CLOVERLEAF FILING 2
 POND PLANS AND DETAILS
 SHEET 19 OF 28
 JOB NO. 25158.01

**POND SF-1 PROFILE
STA 0+00.00 TO 0+71.26**

AS-BUILTS
05/24/2023
SF-21-023

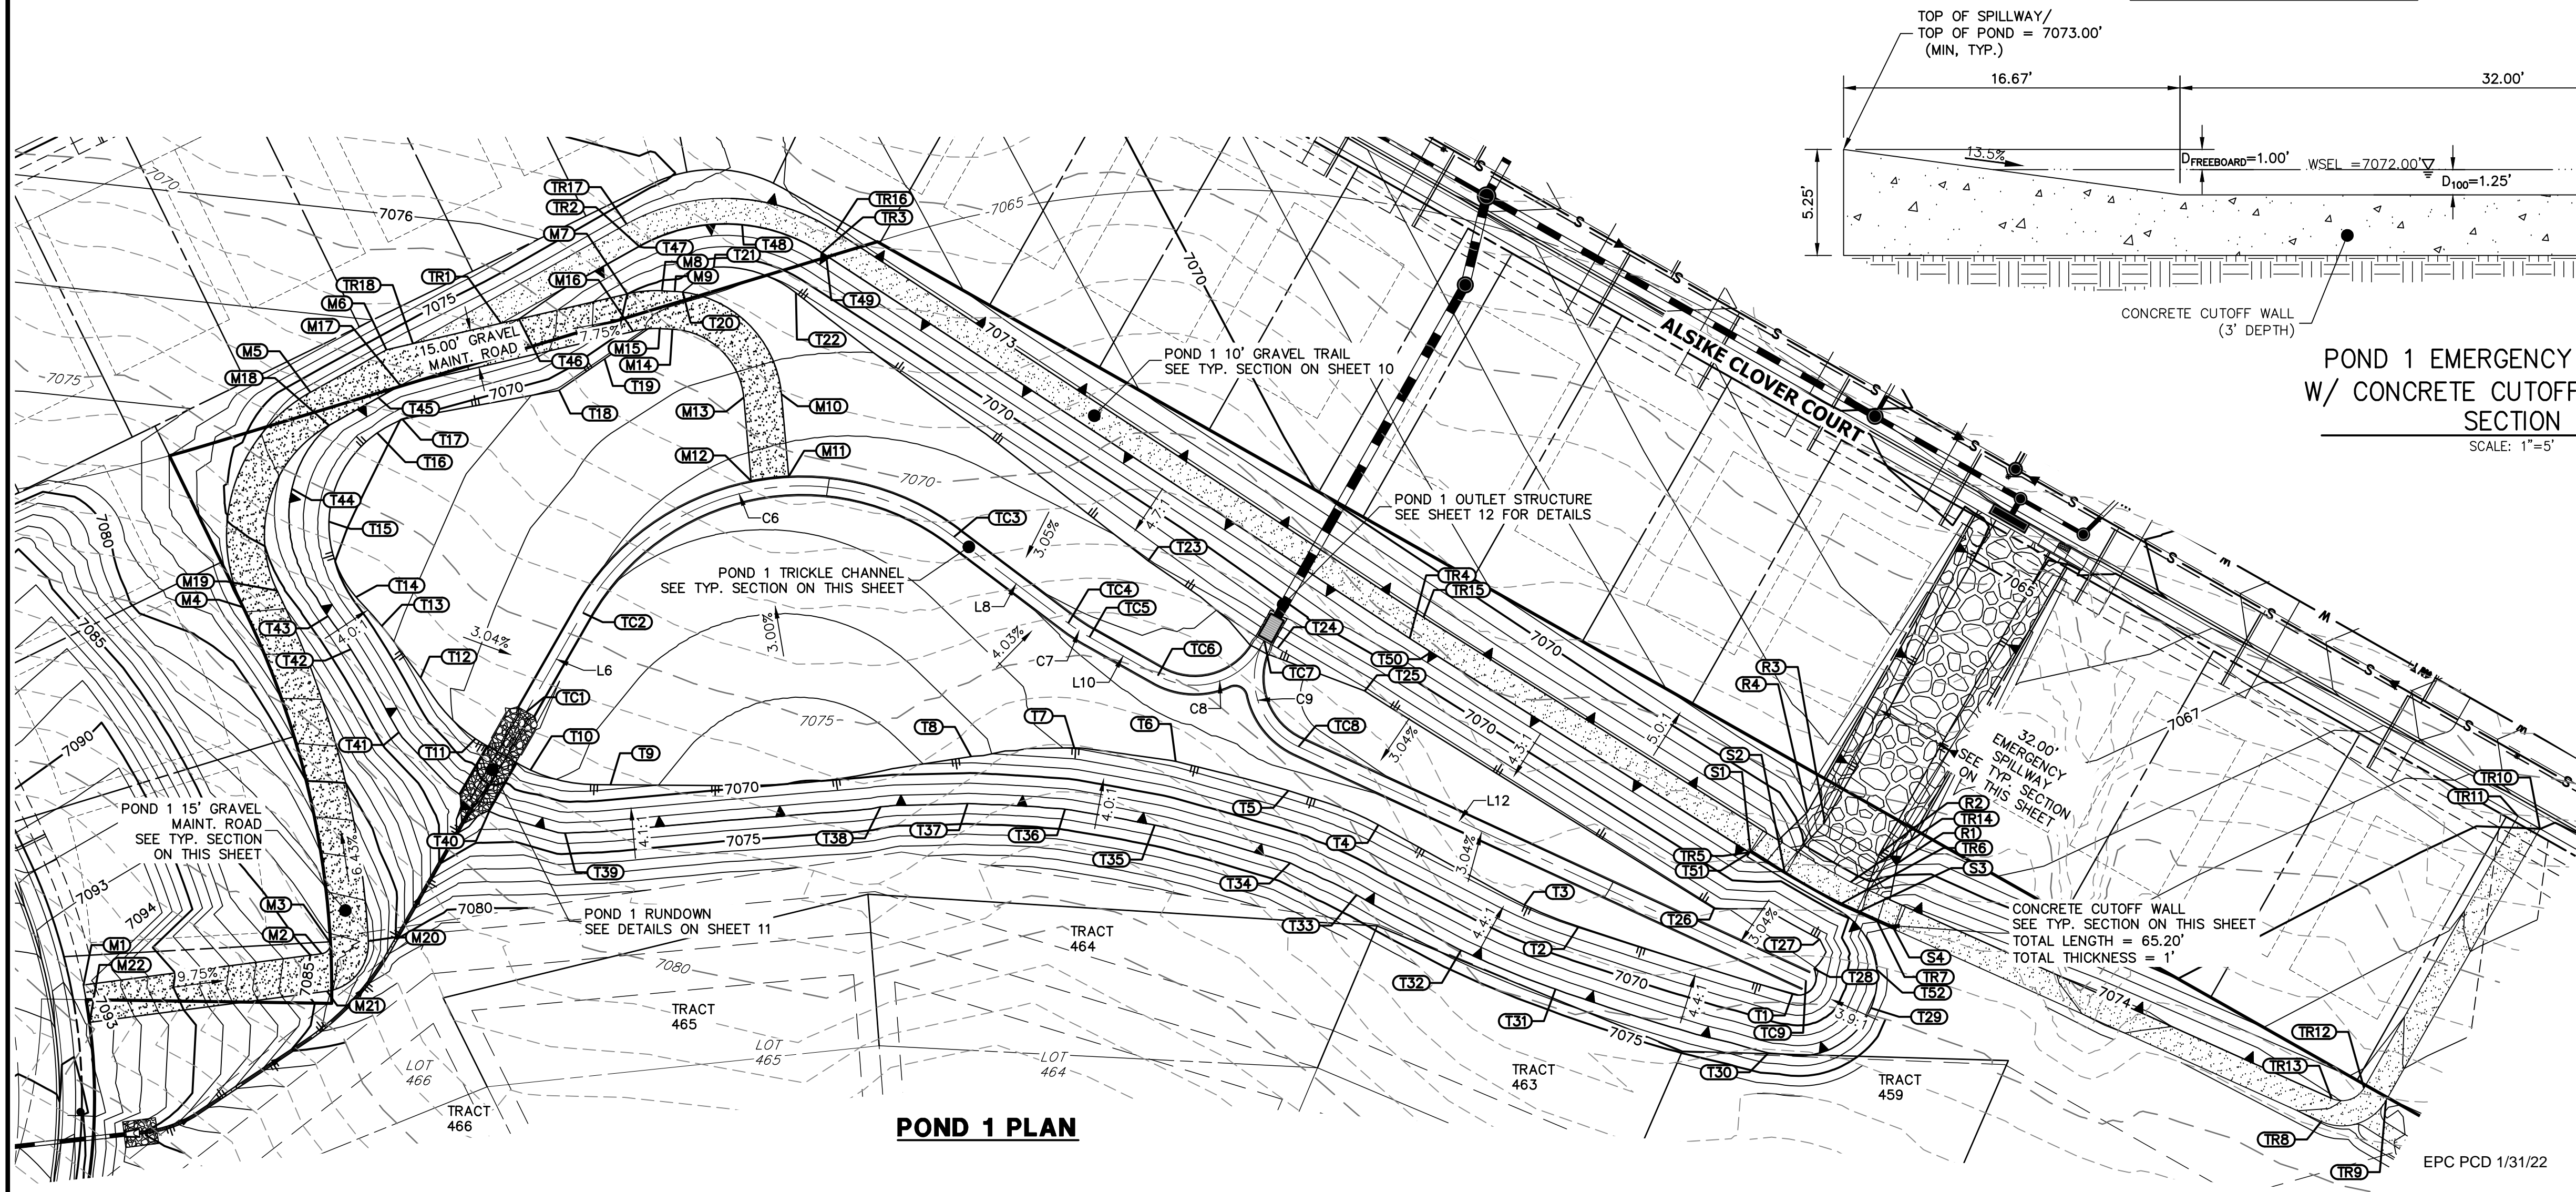
Unresolved previous comment: Retaining wall actually installed closer to street than shown on plan. Reflect this change on as-builts.

Unresolved previous comment: Ditch not installed per plan

This wall was built per plan. This documents is not intended to be an "as-built" for the retaining wall.

This swale has been installed per plan and was confirmed by a field visit, December 2023.
